From: Laura Gibbons <Laura.Gibbons@arun.gov.uk>
Sent: 01 July 2021 16:13
To: Planning.Responses <Planning.Responses@arun.gov.uk>
Cc: Michael Eastham <Michael.Eastham@arun.gov.uk>
Subject: RE: Planning Consultation on: BE/92/21/DOC

Thank you for consulting us on this application to discharge condition 15, we have the following comments:

Application No: BE/92/21/DOC

Site Address: Land At Salt Box West Of Shripney Road Bognor Regis PO22 9NW

HYDROCK PROJECT NO. C-13319-C		SCALE @ A1 AS SHOWN
STATUS DESCRIPTION AS BUILT ISSUE		STATUS A
DRAWING NO. (PROJECT CODE-ORIGINATOR-ZONE-LEVEL-TYPE-ROLE-NUMBER) SAL-HYD-00-ZZ-DR-C-7101		REVISION C04

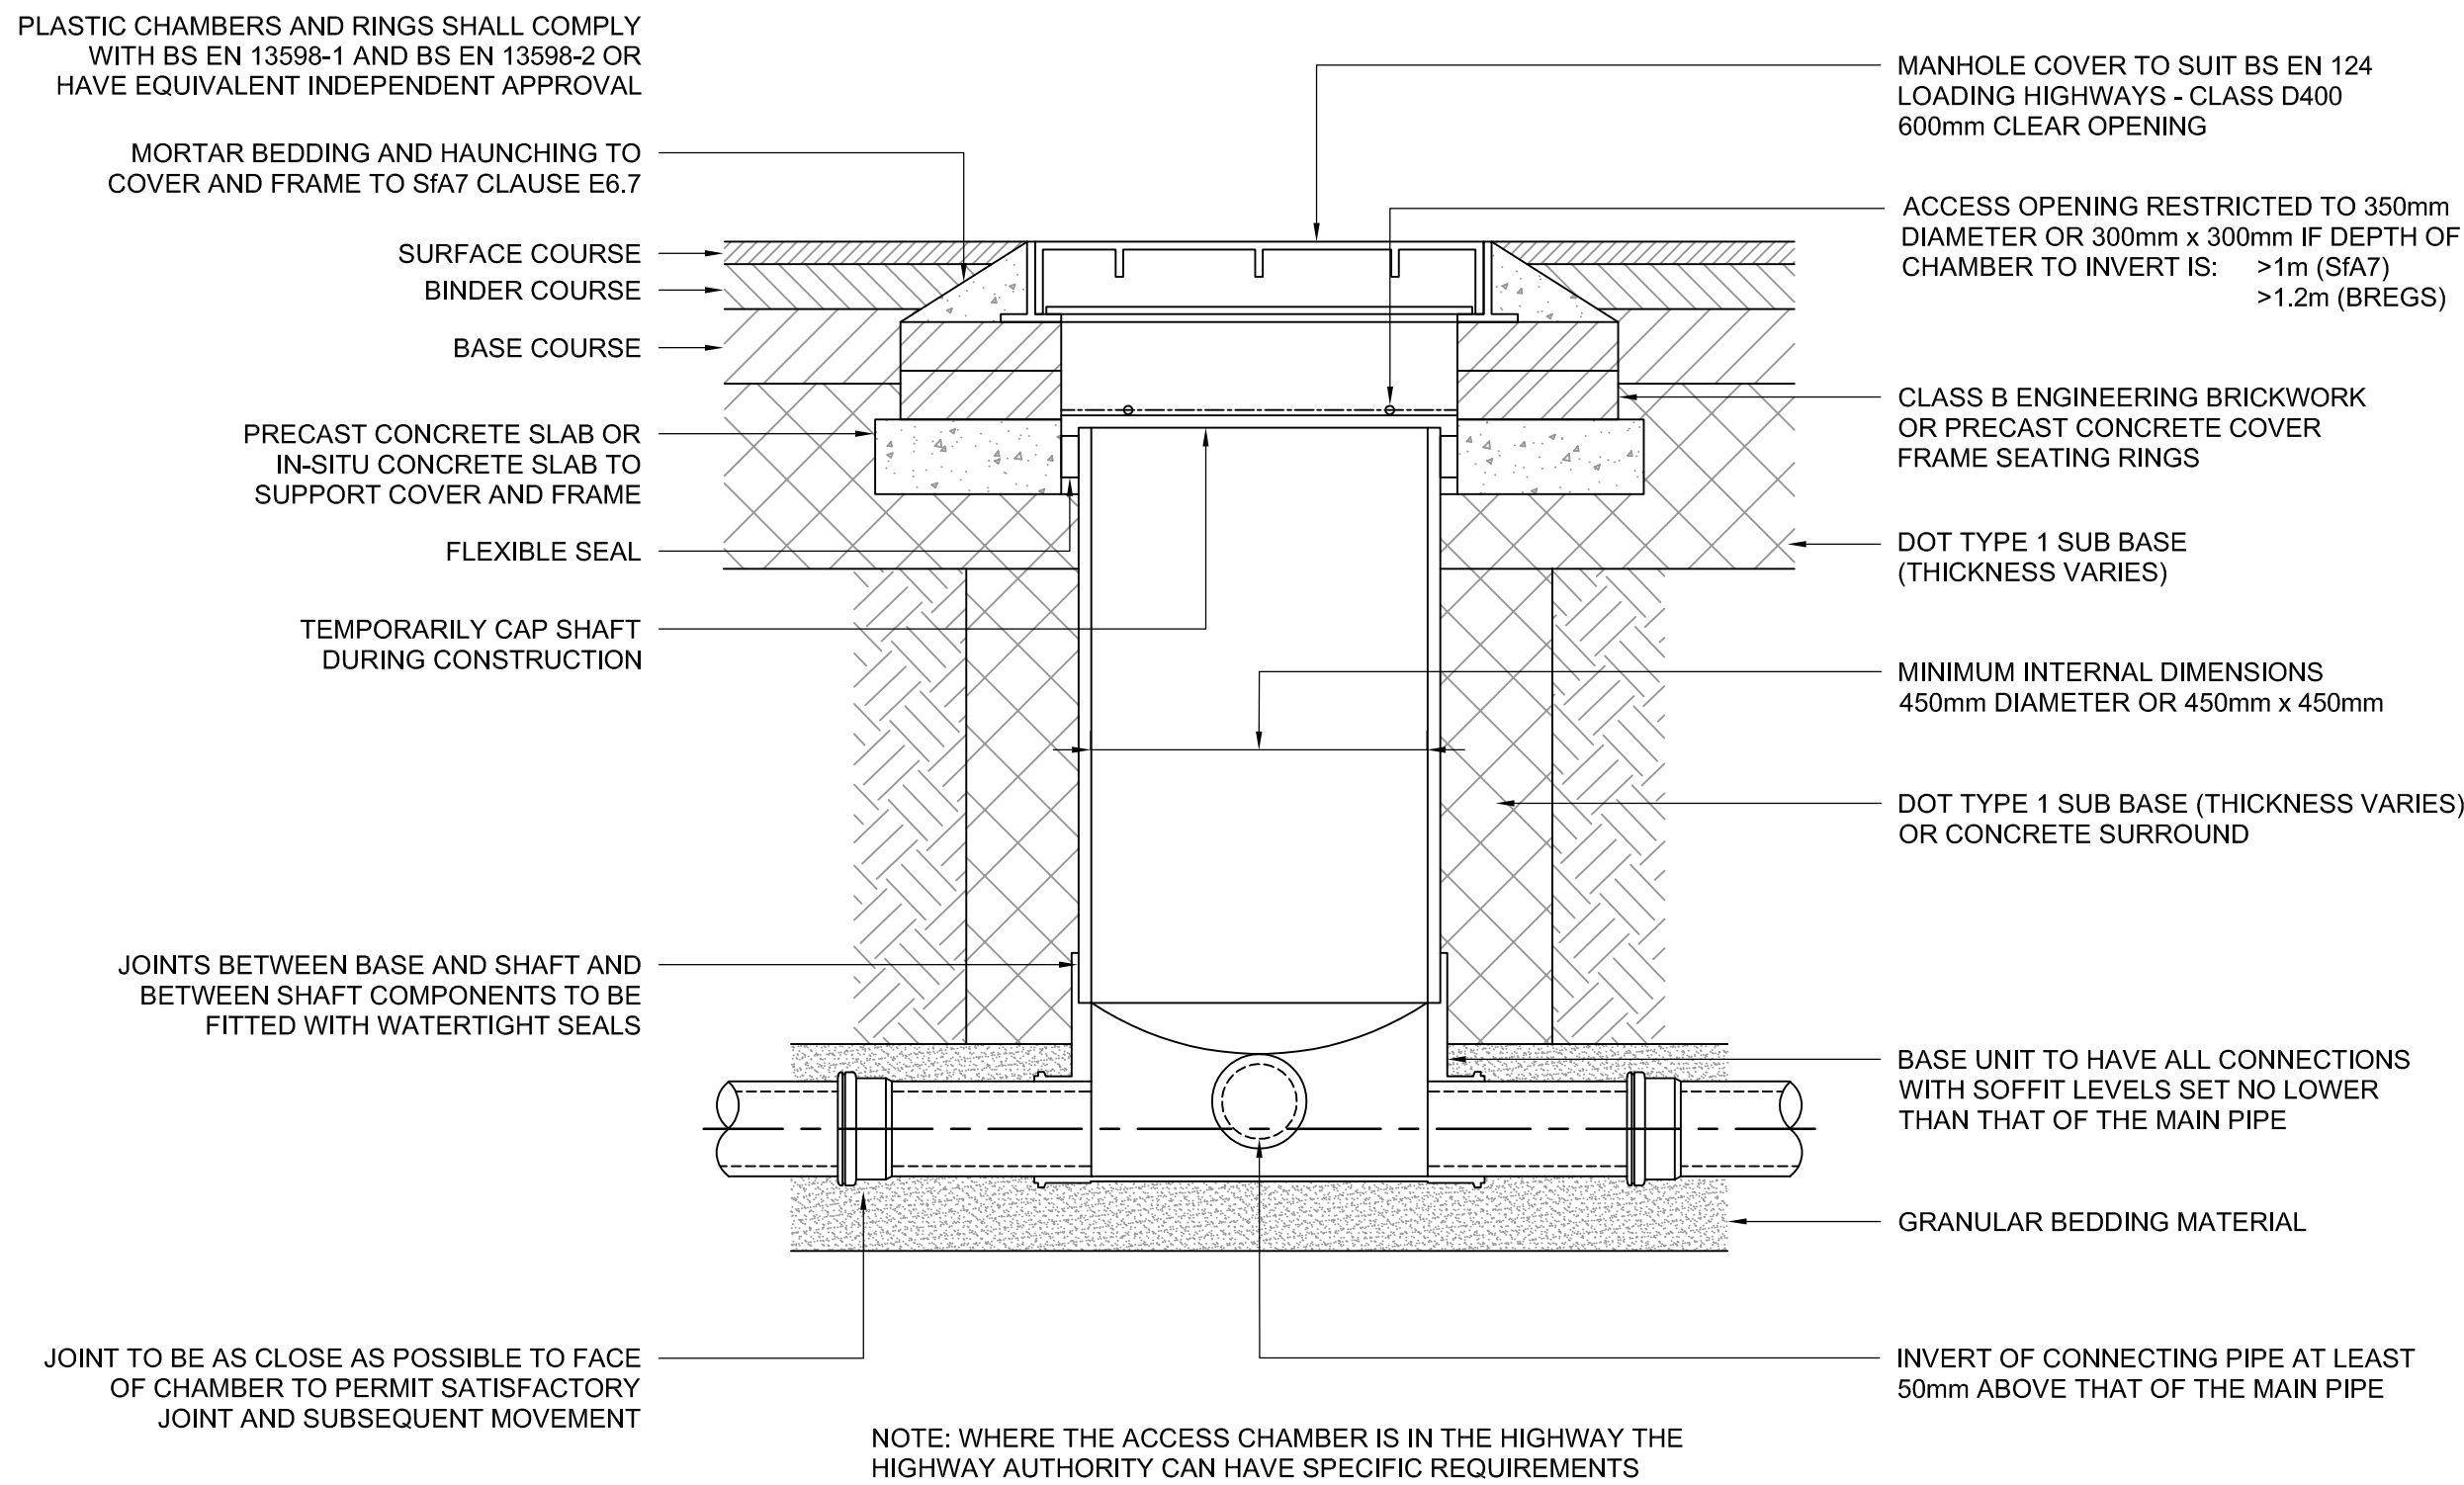
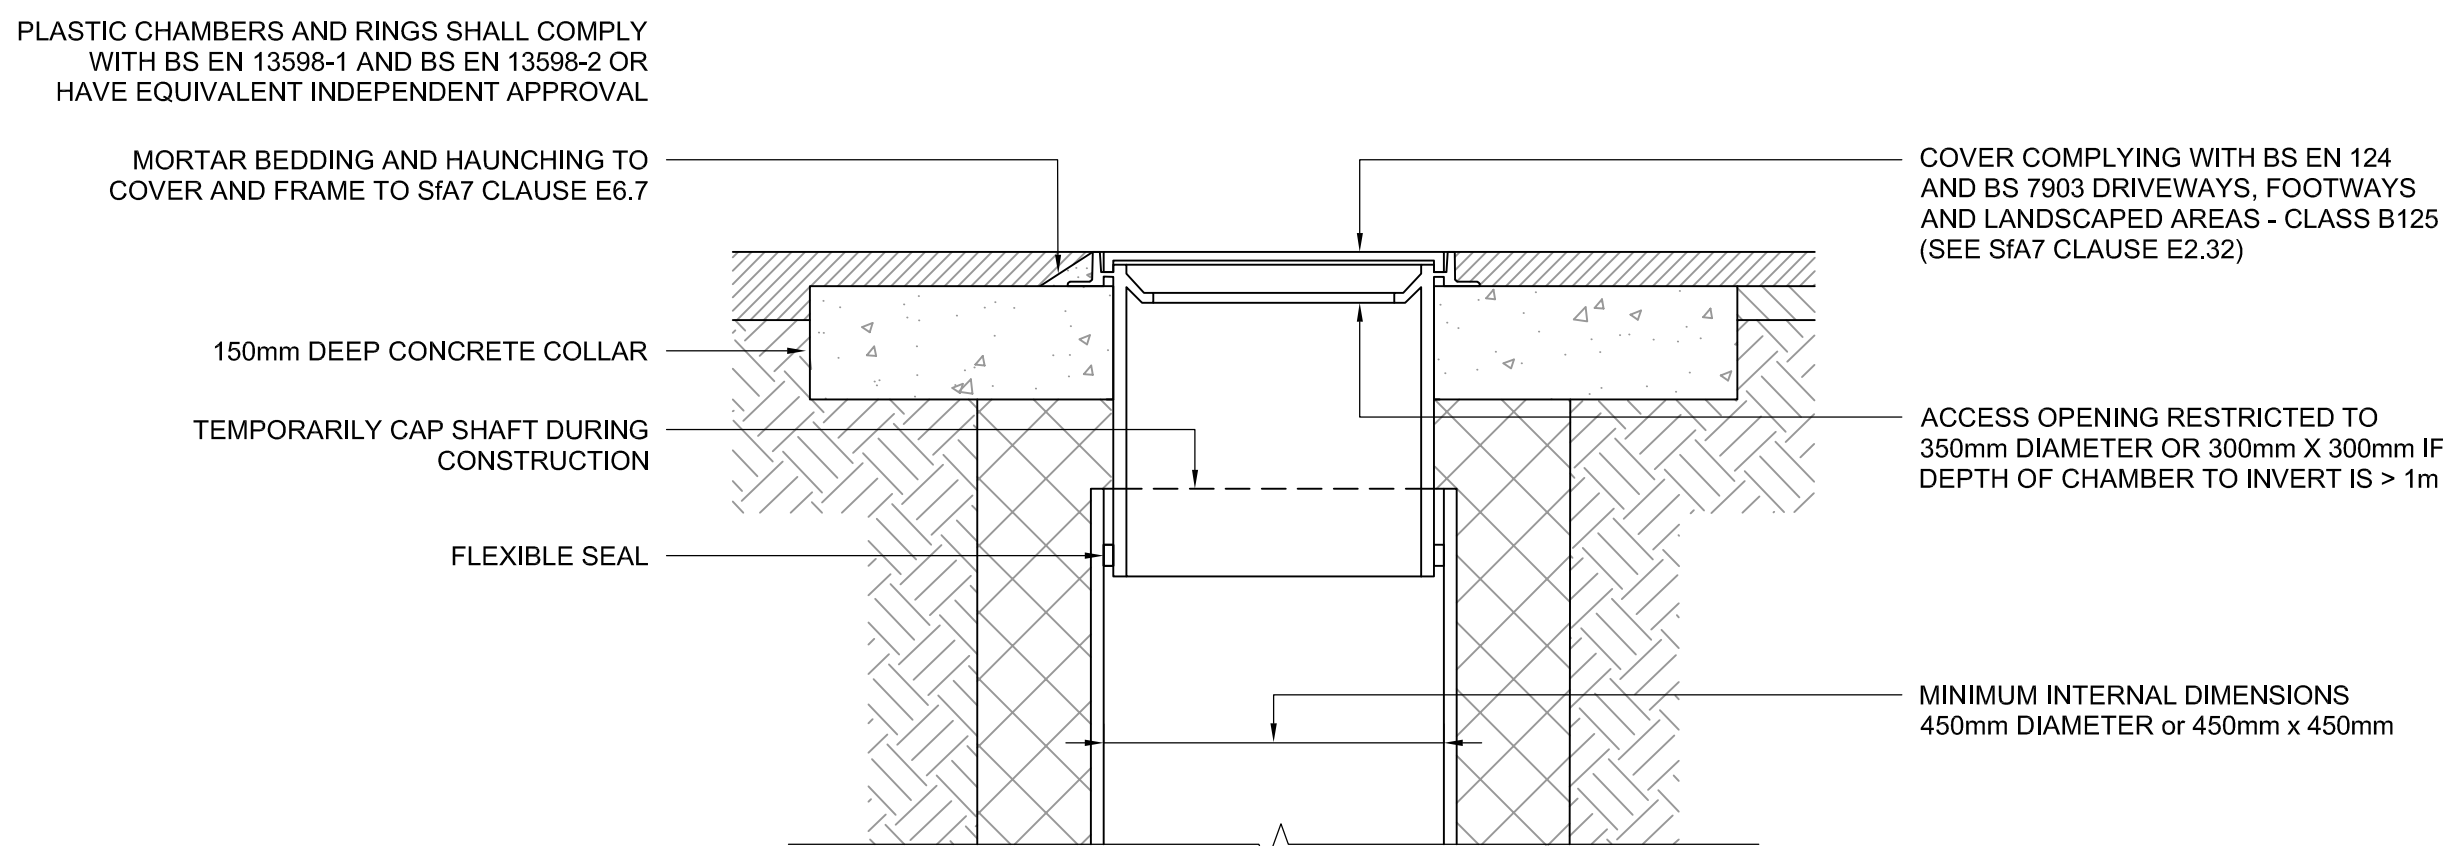
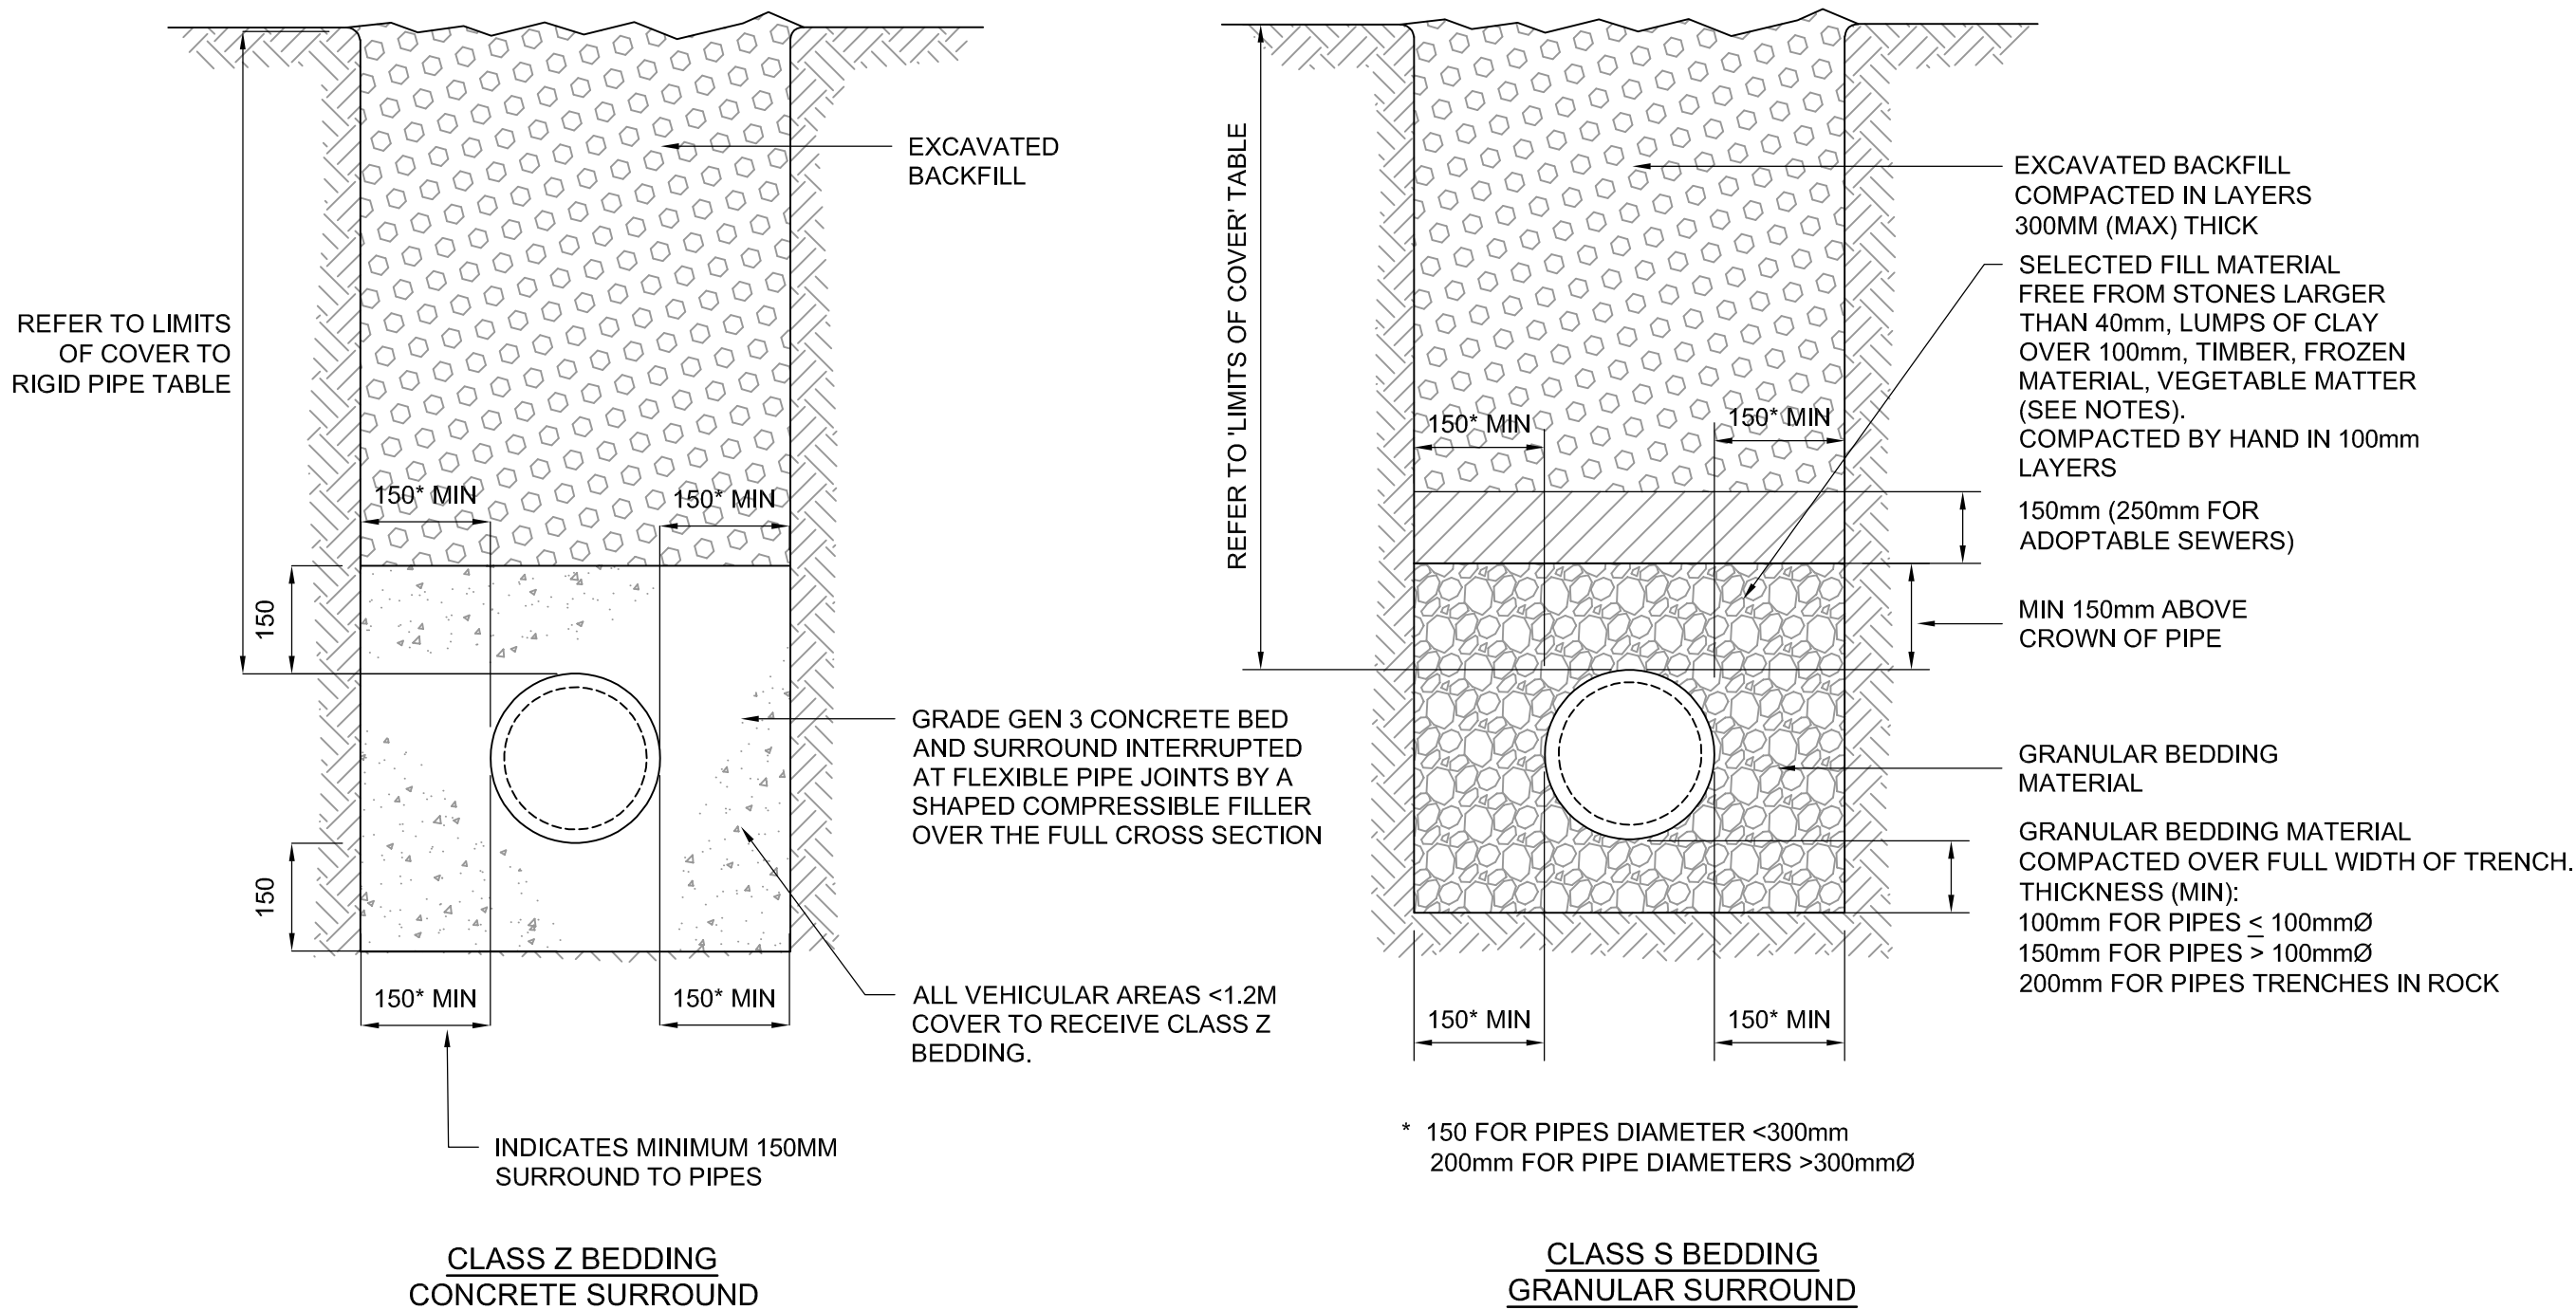
2. The as built survey doesn't include the invert level of the storage features. Please include this.
3. The as built survey doesn't include levels of the permeable paving, please include this.

4. There are numerous pipes on the as built drawing which do not include pipe fall or diameter. Please ensure that all pipes are labelled with diameter and fall.

5. Please confirm dimensions of attenuation features on plan.
6. There appear to be significant levels discrepancies between the as built plans and the approved drawings.
